From: [REDACTED]
To: [Cleve Hill Solar Park](#)
Subject: Natural England Deadline 2 submission
Date: 26 June 2019 19:29:37
Attachments: [REDACTED]

David Rose
Lead Member of the Panel of Examining Inspectors
Cleve Hill Solar Park Case Team
The Planning Inspectorate

NSIP Reference Name / Code: EN010085 Cleve Hill Solar Park
Natural England's submission for Deadline 2: Written Representation and Answers to the Examining Authority's First Written Questions

APPENDIX 1 – WINTERING BIRD NOISE THRESHOLD

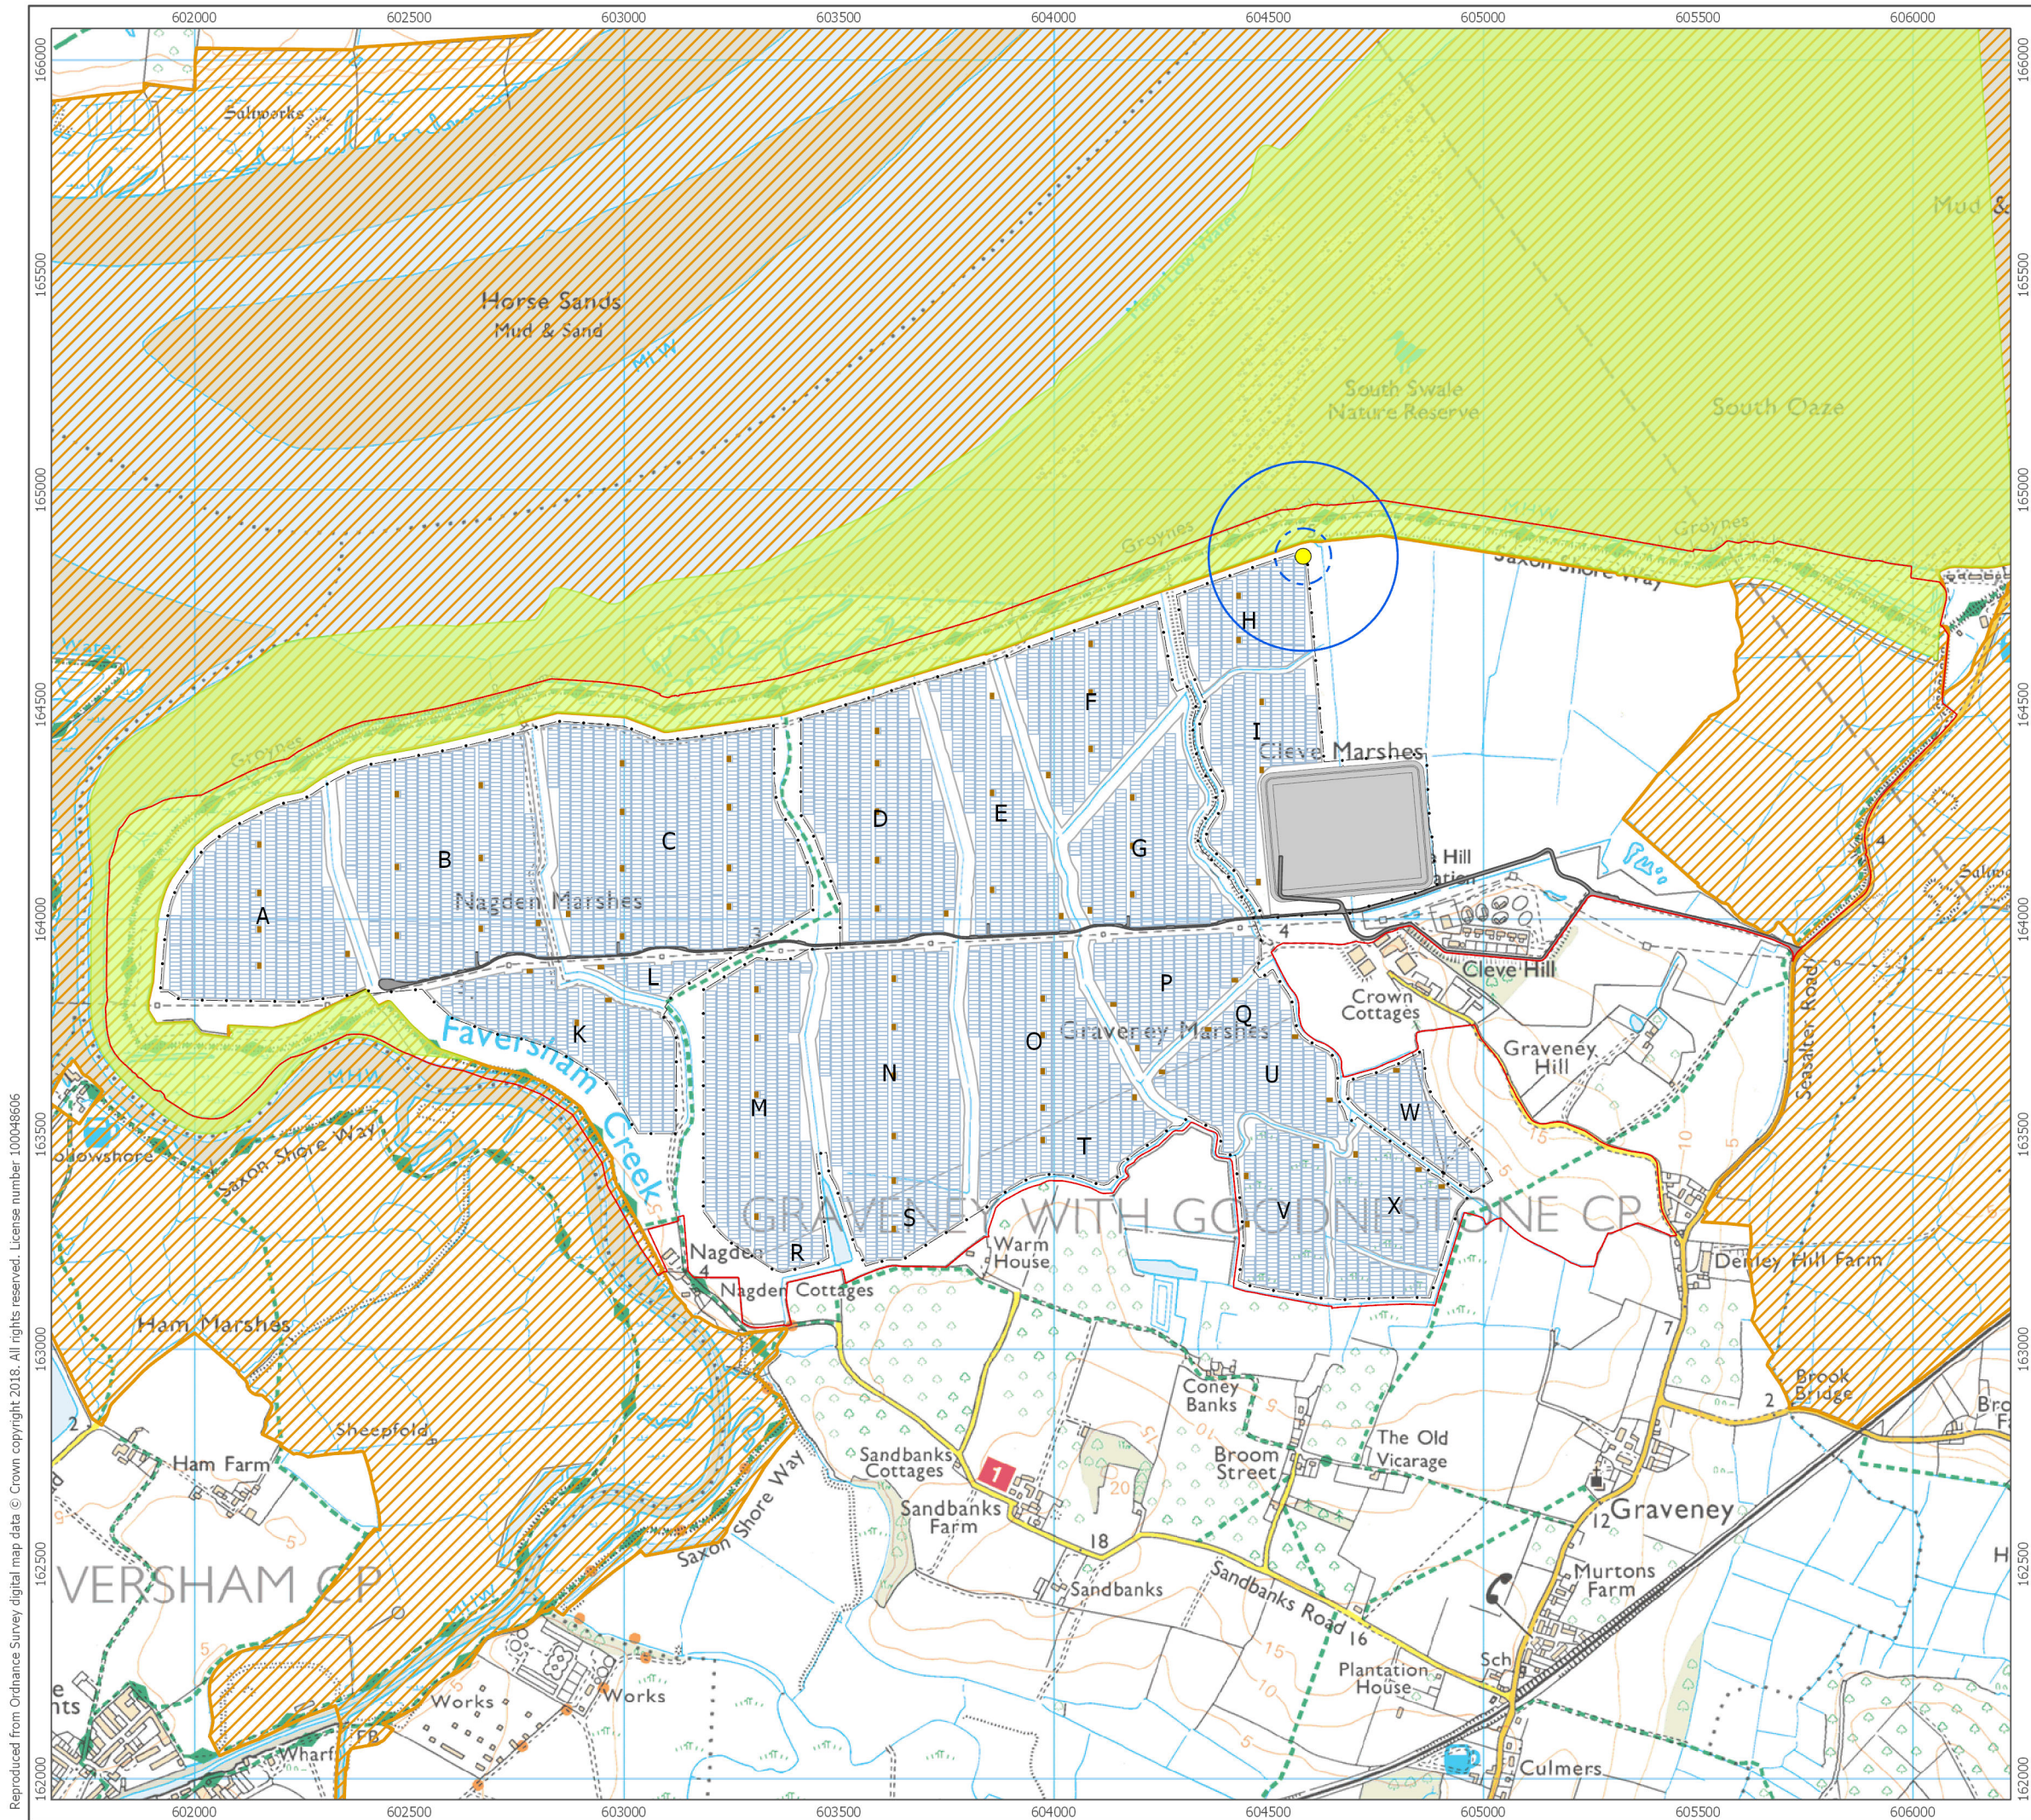
3.2.3. Whilst Natural England does not agree with the use of noise thresholds to predict whether there will be adverse impacts (as impacts are site and species specific), we agree they are helpful in assessing potential for impacts. Figure 3 in the Report to Inform an Appropriate Assessment (RIAA) [APP-026] shows that the 70dB_{L_{Amax}} noise contour does not reach the intertidal area. However, the 55dB_{L_{Amax}} contour extends 320m from the source of the piling, and hence extends into the intertidal. Therefore, there is the potential for wintering birds to be impacted. This applies particularly to birds roosting at Castle Coote, as options for alternative high tide roosts are more limited than foraging areas, and birds are pushed closer to the source of disturbance by the high tide.

3.2.4. Disturbance mitigation measures are set out in the Outline SPA Construction Noise Management Plan (CNMP) [APP-243], which are welcomed. However, in our Relevant Representation [RR-827] Natural England raised concerns that these were not sufficient to be certain that adverse impacts would be avoided at high tide. This issue has been discussed through the Habitat Management Steering Group (HMSG) and the group agreed that timing of piling works closest to Castle Coote should take place outside the core wintering period (November to February

inclusive). The Applicant has indicated, through our common ground discussions, that an updated SPA CNMP will be submitted that will include timing restrictions on piling to avoid disturbance to birds using the high tide roost at Castle Coote. Subject to the detail contained in an updated SPA CNMP, Natural England confirms this is an acceptable approach to mitigating disturbance to wintering birds.

APPENDIX 2 – BREEDING BIRD NOISE THRESHOLD

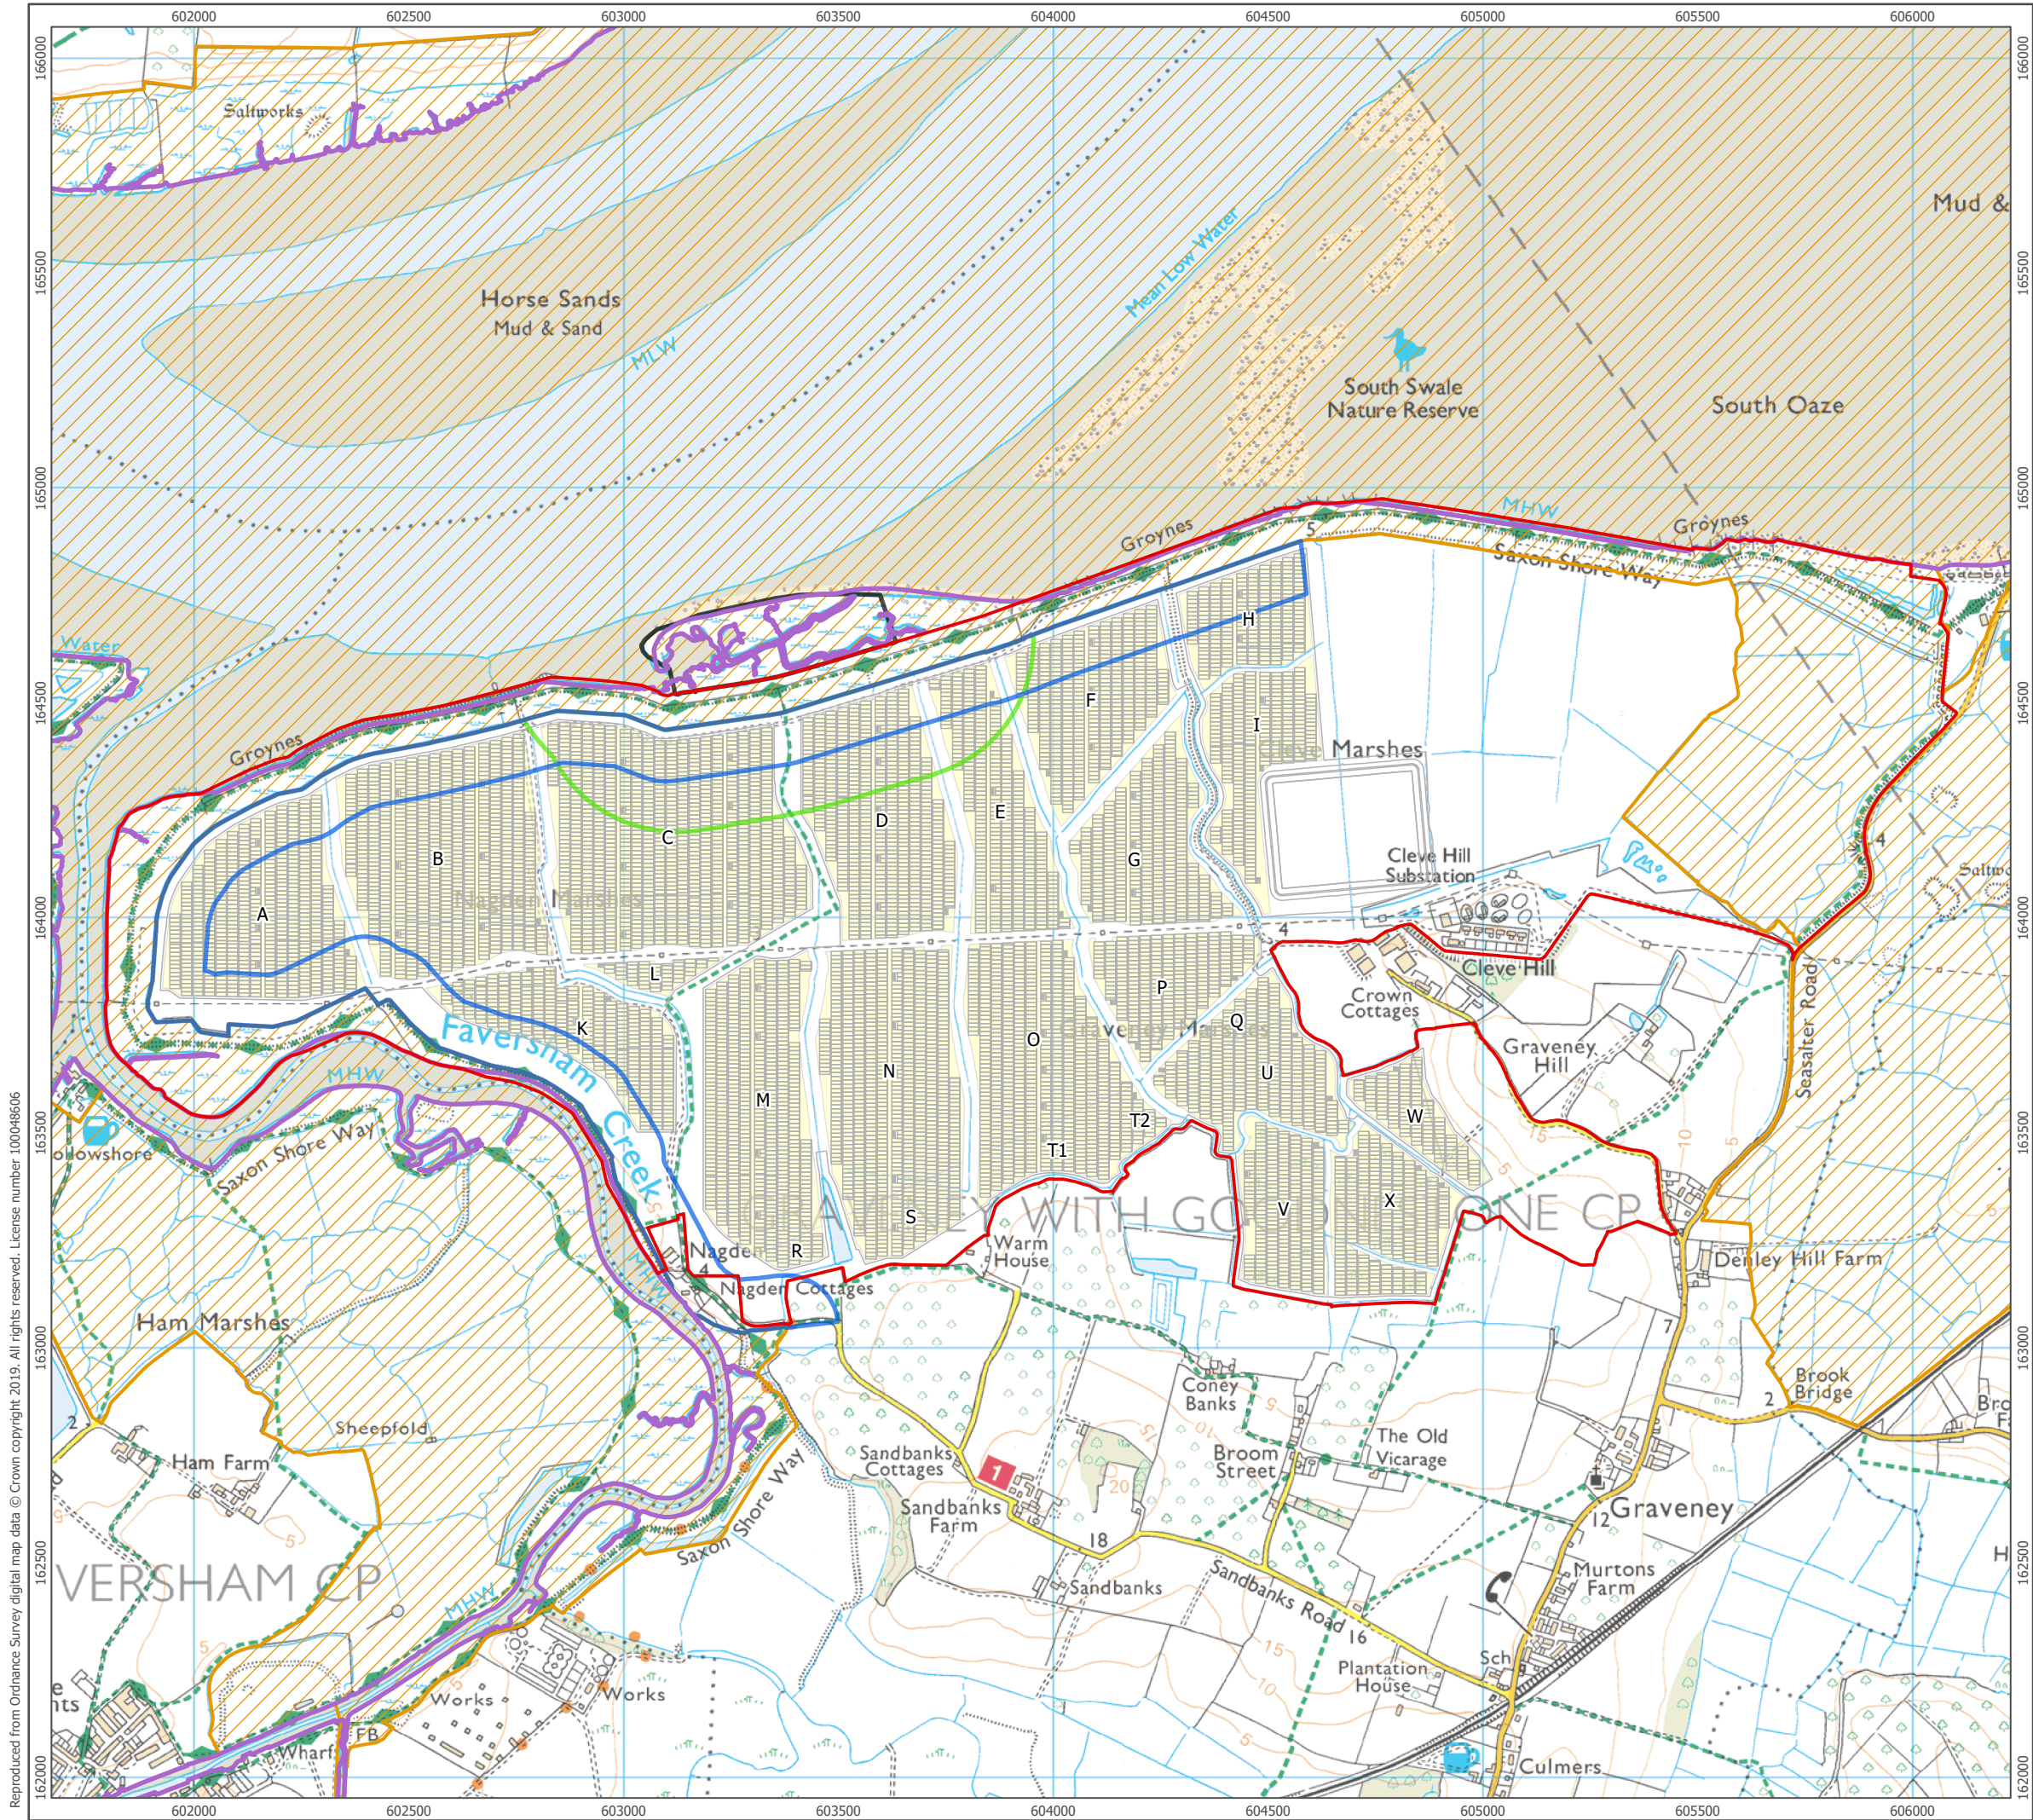
- 3.2.6. In our Relevant Representation [RR-827], Natural England raised concerns as to whether the mitigation measures set out in the Outline SPA CNMP [APP-243] and the Breeding Bird Protection Plan (BBPP) (Appendix B of the Outline Construction Environment Management Plan) [APP-205] gave sufficient certainty that impacts would be avoided. In particular, the BBPP states (paragraph 158) that 'where practicable' construction activities closest to The Swale will be avoided. Through our common ground discussions, the Applicant has confirmed that the intention of this statement was to avoid restricting activities that do not exceed the noise threshold, and has agreed to review the wording of the BBPP to provide greater certainty and clarity.
